August 27, 2021

Project #21-1250

At your request, a limited foundation inspection of a pool house located at 188 Mels Meadows Drive, Fuquay Varina, NC 27526 on 8/13/2021 to inspect and evaluate the as-built condition. The report that follows has been prepared based on that inspection.

FOUNDATION PLAN, SCHEDULE

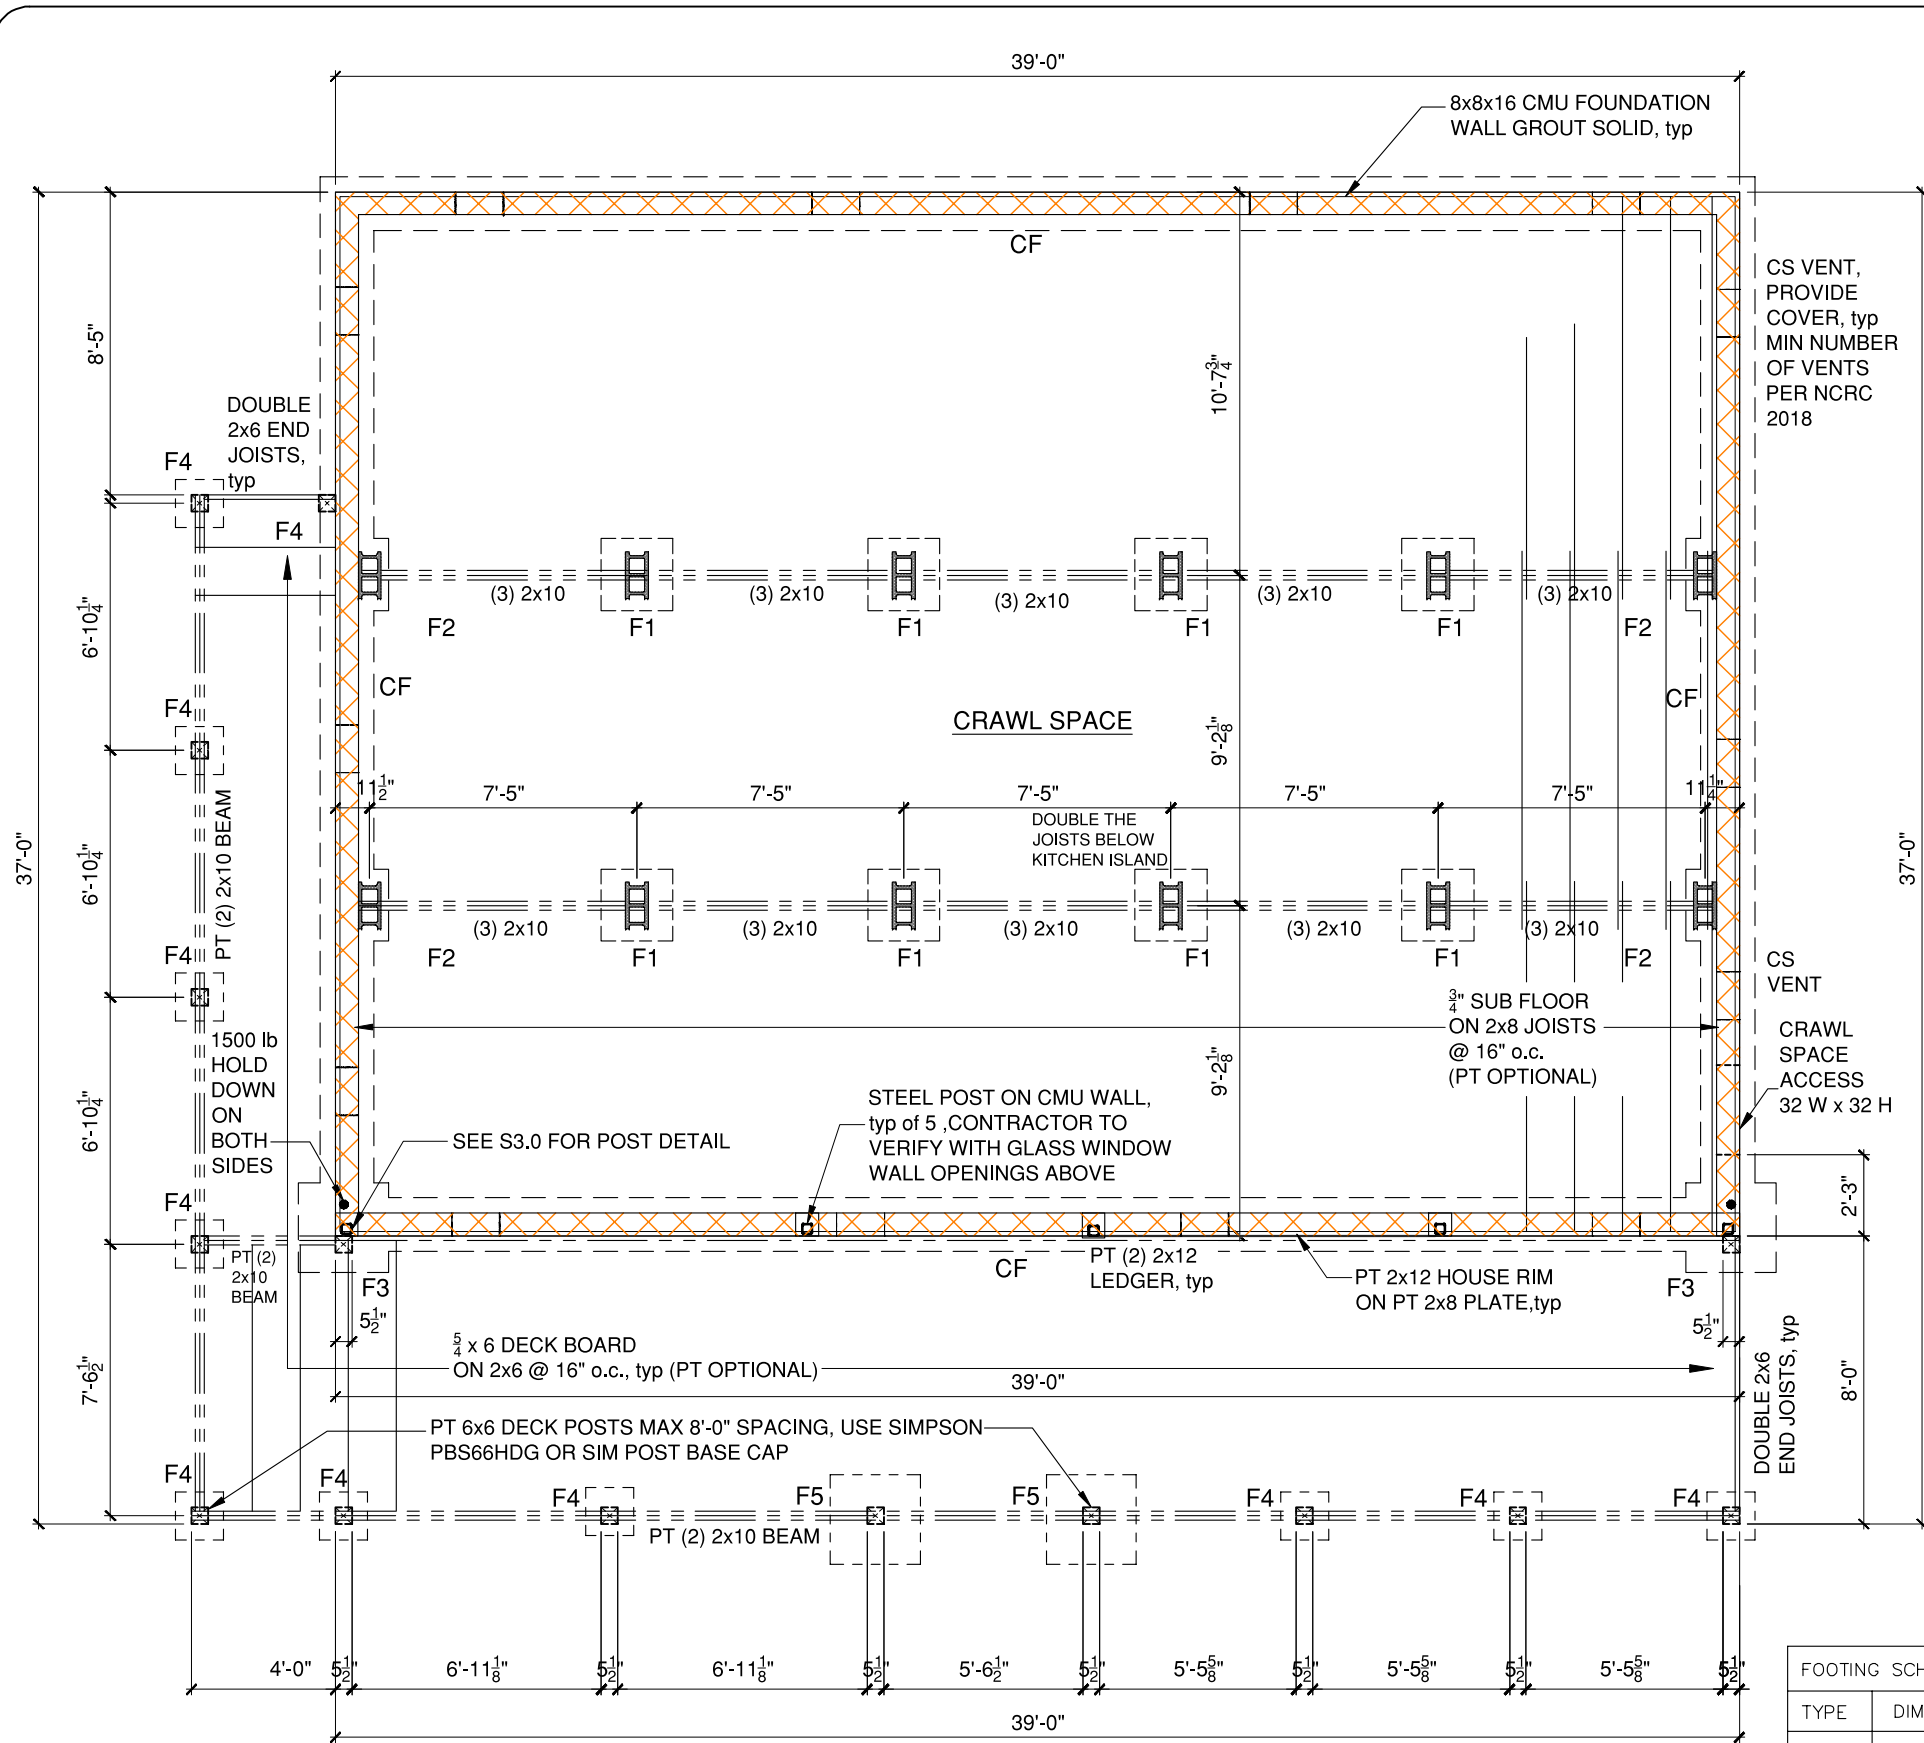
The foundation/wall construction meets the design requirement of the permit plans. Adequate rebars on the cmu wall are placed per the design drawings. Additionally, a complete grout filled foundation wall is recommended, which is not the requirement. Based on the site inspection and evaluation, the foundation construction meets the requirement of NCRC 2018.
